CITY OF ALBUQUERQUE

PLANNING DEPARTMENT – Development Review Services

February 19, 2015

**RE: American Toyota (File: C18D012)
Drainage Report and
Grading and Drainage Plan, Engineer's Stamp Date 2-5-15**

PROPOSED LAYOUT (SYSTEM #2)

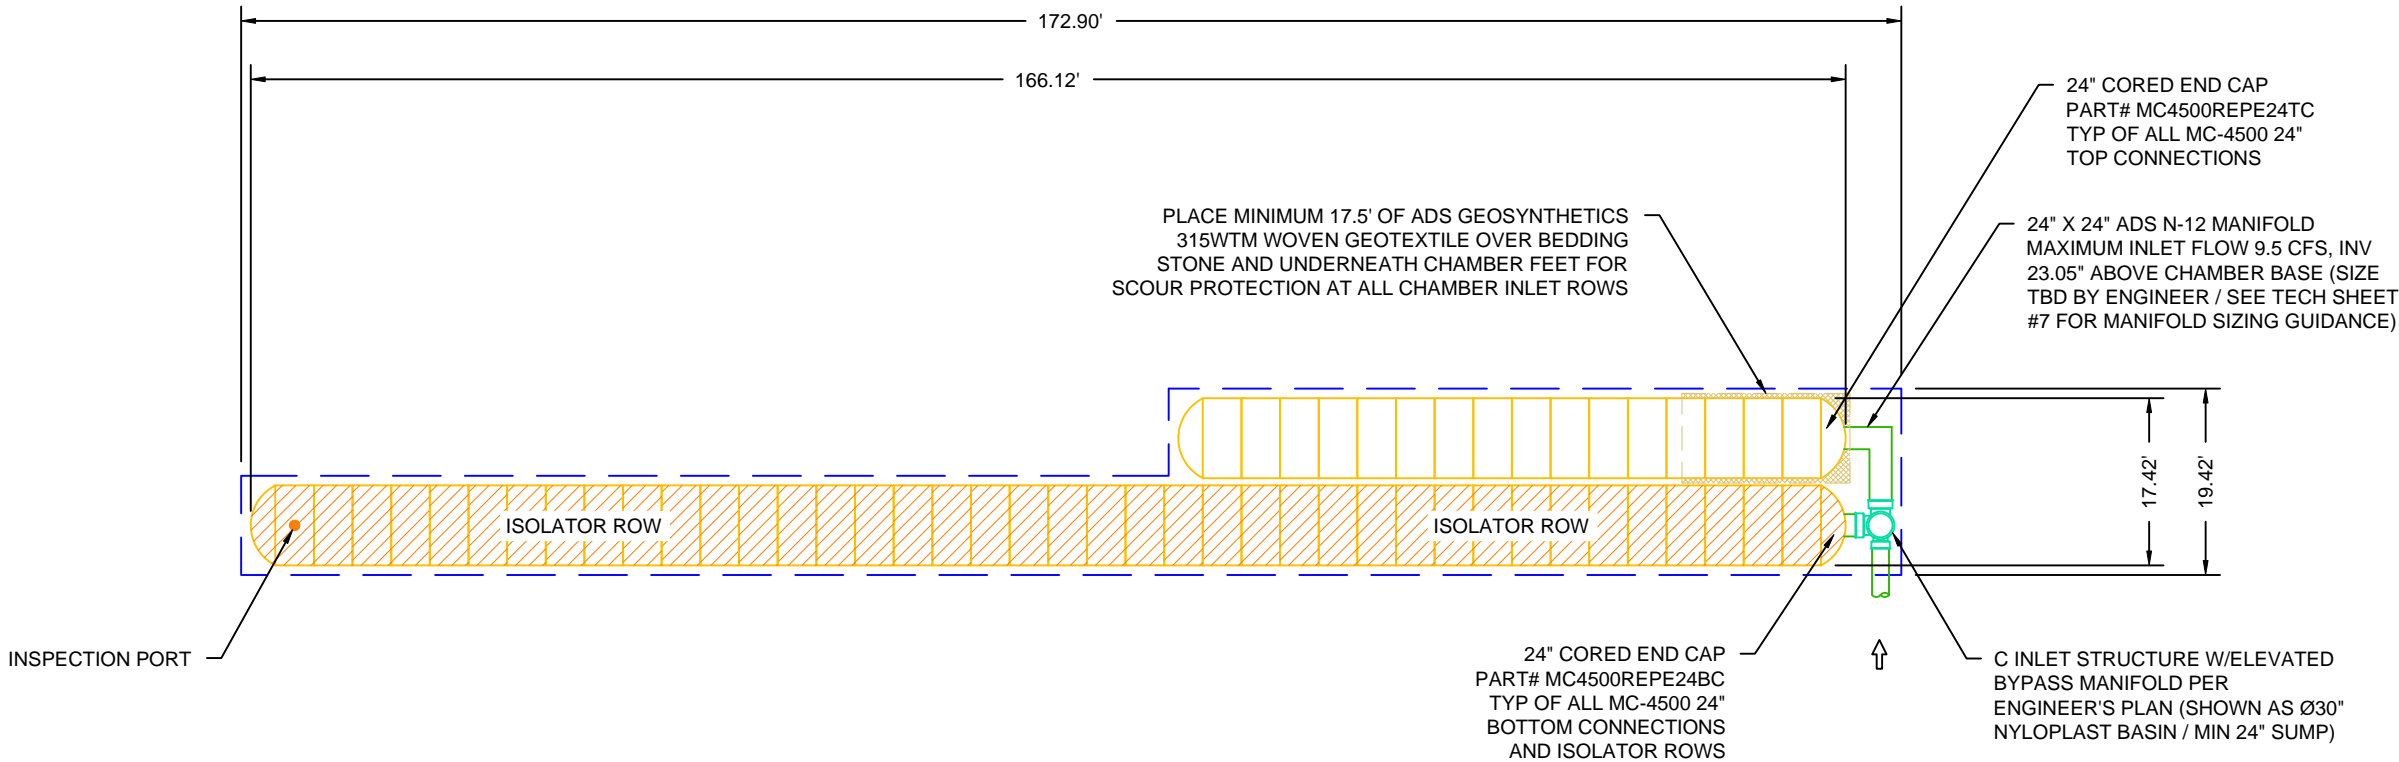
- c. Inlet invert is 2' higher than the manifold invert
12. Regarding the StormTech System #2
 - a. The top of the baffle elevation should be at the elevation as where the first flush is captured. StormTech's calculation sheets indicate it is about 5204.2. How is the top of baffle being determined?

- b. What is the invert of the existing 24" storm drain? How will this affect the height of the Baffle?
 - c. What are the invert elevations at the manhole?

- d. South D-Inlet should have 2 invert elevations and should match StormTech's inverts. North D-inlet should match the manifold invert
 - e. The manhole detail should detail how the baffle is intended to be constructed .

- f. StormTech drawing shows a flow arrow into system at south end that seems incorrect.
13. Regarding the StormTech System #3,
 - a. Show invert elevations at the D inlets and Manhole

PROPOSED ELEVATIONS (SYSTEM #4)

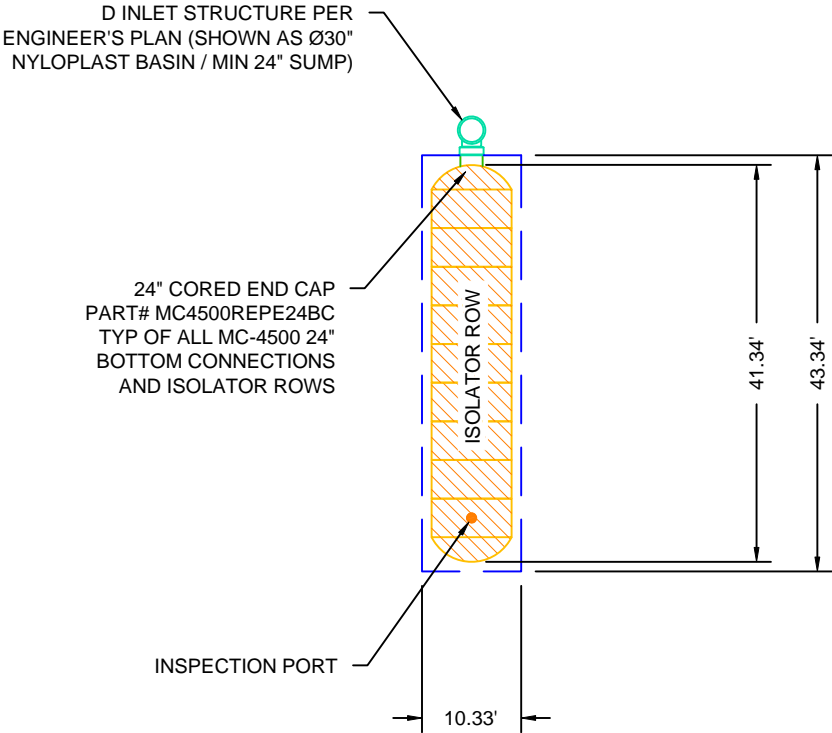
14. Regarding the StormTech System #4/5,
 - a. the D inlet has an invert elevation = 5223.50, and StormTech shows " 24" isolator row invert = 5219.94." Inverts don't match.

- b. StormTech Plan shows a pipe coming into the west inlet.
 - c. Are there connection details from the 24" pipes to the inlets?
 - d. StormTech drawing shows a flow arrow into system at west end that seems incorrect

INSTALL STORMTEC
CHAMBER —SEE SHEET
FOR SPECIFICATIONS

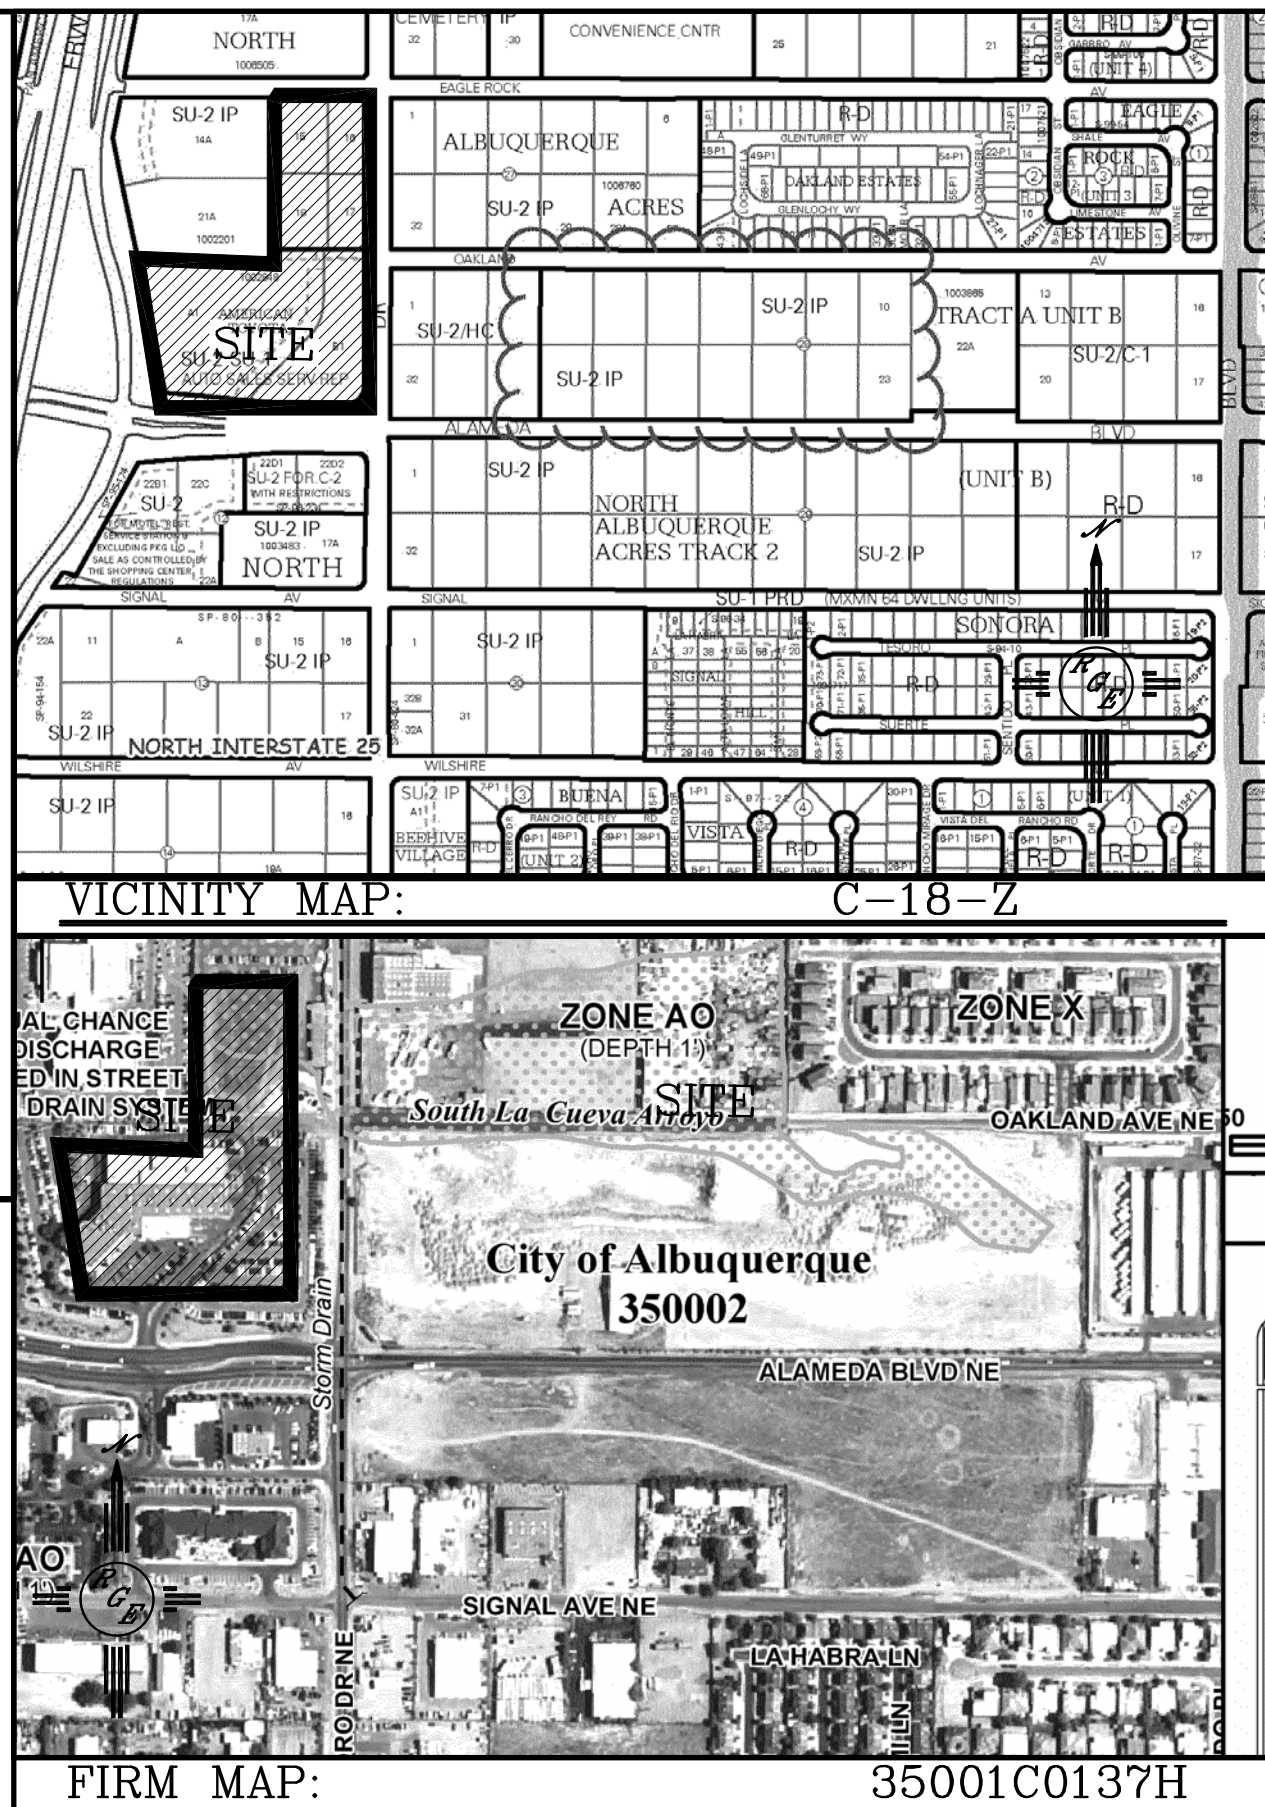
- e. Perhaps there could be opportunity to collect some first flush in the parking islands and landscaping?
2. To be sure that runoff from Basin B fills up the StormTech Chamber, grading around the inlets should direct runoff to the inlets.

5. NMDOT had some comments about the washout. How will this be handled in the proposed plan?
6. Provide a benchmark and datum on the Grading and Drainage Plan.

7. On the G&D plan, the leader notes indicating the StormTech chambers should also note the System # it corresponds to. Likewise, StormTech should be labeling the Systems on the sheet that shows all 4 systems, cut from the G&D plan.

8. The flow arrows on the north side of the roof are in the wrong direction. Show a ridge line to indicate where the divide occurs.
9. Typos: On the Proposed basin plan, Basin C has verbiage calling it basin B. Basin B is has verbiage calling it basin A.

10. Size channel rundown at south end of site.
11. Regarding the StormTech System #1
 - a. So that runoff is captured by the new D-inlet, it should be lower than the existing inlets. What is the grate elevation of the existing inlets. Please note the location and type of the existing inlets.

- b. The D-inlet should be upstream of the 3 existing inlets so that when the chambers fill, there is sufficient capacity of the 3 inlets to capture the overflow.
